Your Ref: 2025/90387

Our Ref: A006812

Site of Former Perseverance House, St Andrew's Road, Huddersfield - Discharge of details reserved by conditions 12 (drainage strategy) and 15 (interceptor details) on previous permission 2024/91336 for erection of two storey office/workshop with detached store and associated works

Yorkshire Water object to the discharge of condition 12.

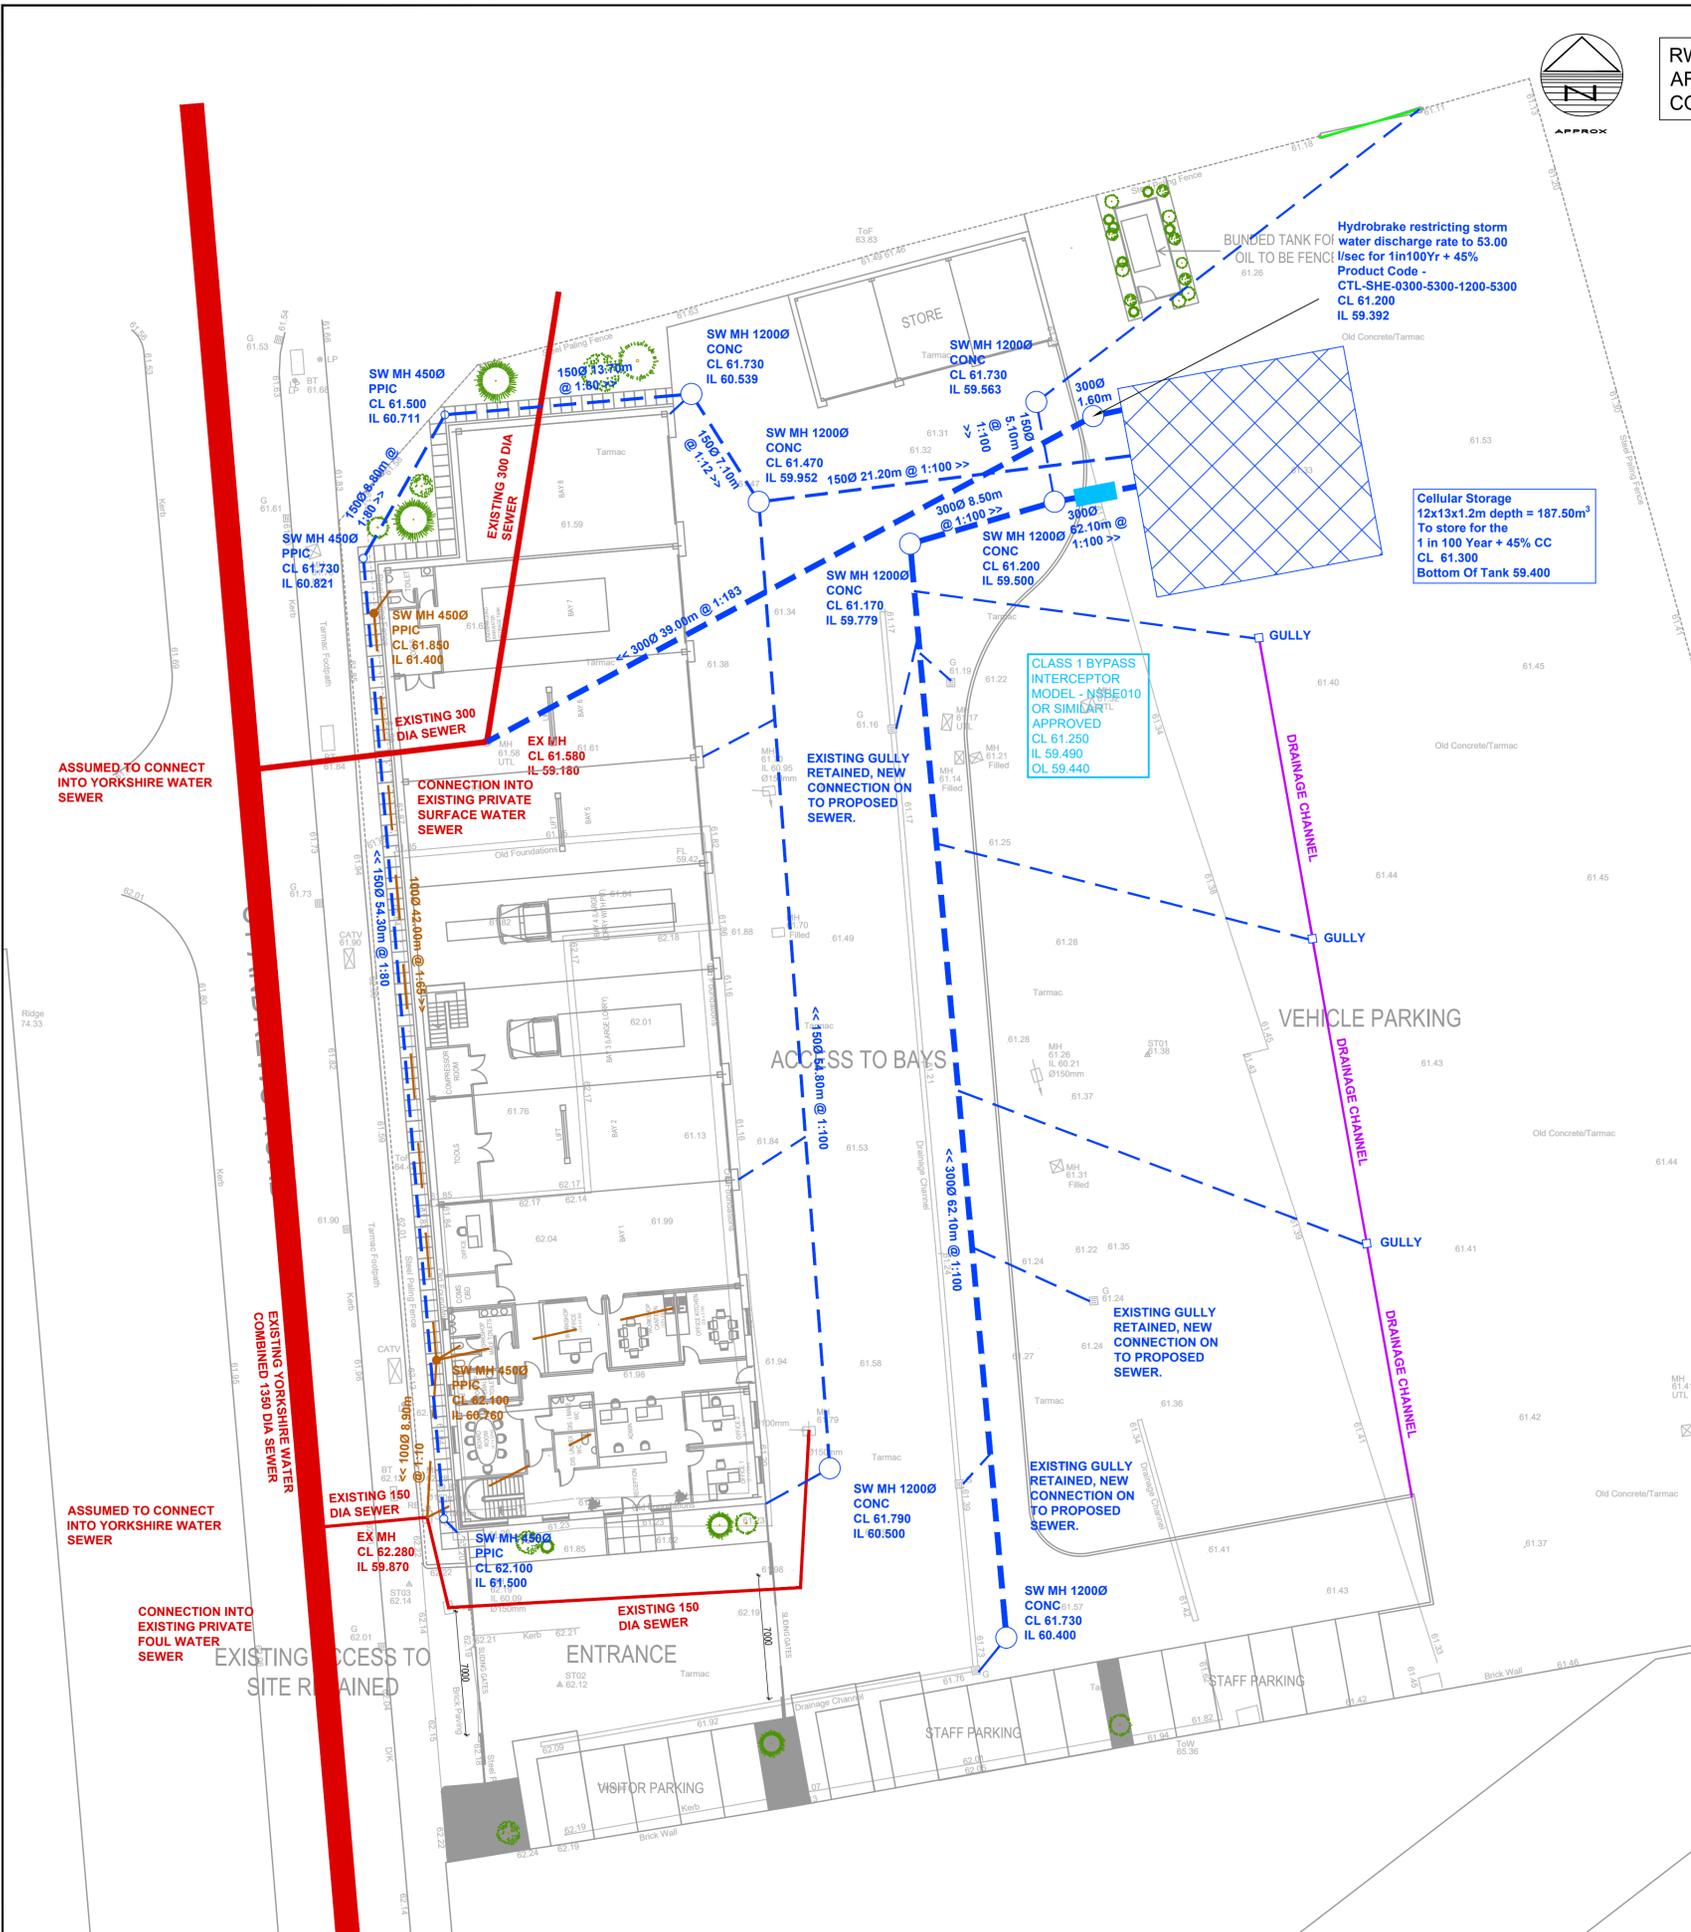
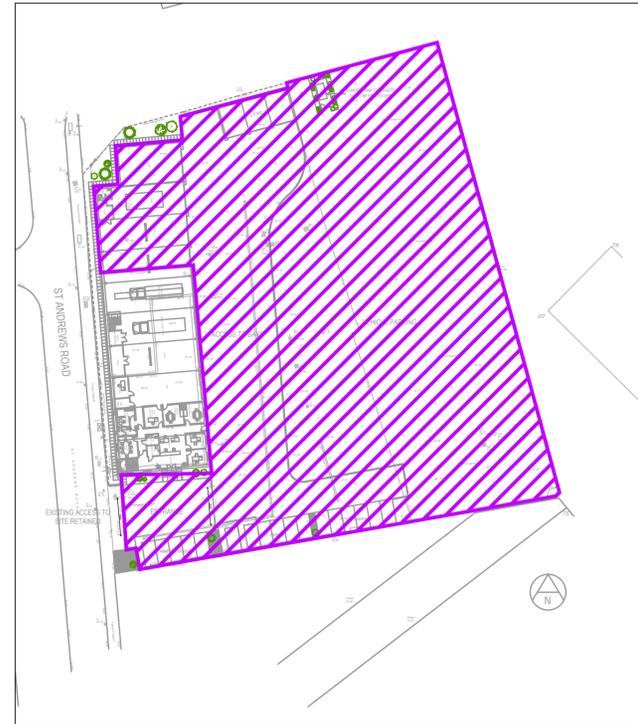
2) The drainage details submitted on drawing 24466-DR-C-0100 (revision P1) dated 09/12/2024 that has been prepared by Dart Engineers require amendments. The following point should be addressed:

a) evidence of existing impermeable areas positively draining to the public sewer is required to prove rate of discharge

3) As a last resort, curtilage surface water may discharge to public sewer. Surface water discharges to the public sewer must have a minimum of 30% reduction based on the existing peak discharge rate during a 1 in 1 year storm event. Any discharge of surface water from the site should discharge to similar points of connection to that of the existing use of the site. You will need to demonstrate positive drainage, based on a 1 in 1 year storm, to the public sewer to Yorkshire Water by means of investigation and calculation carried out at your expense.

To do this, Yorkshire Water requires to see existing and proposed drainage layouts with pipe sizes, gradients, gullies, downpipes and connection points, measured impermeable areas of the present and proposed use of the site, along with the calculations that show the existing and proposed discharge rate from the site to the public sewer.
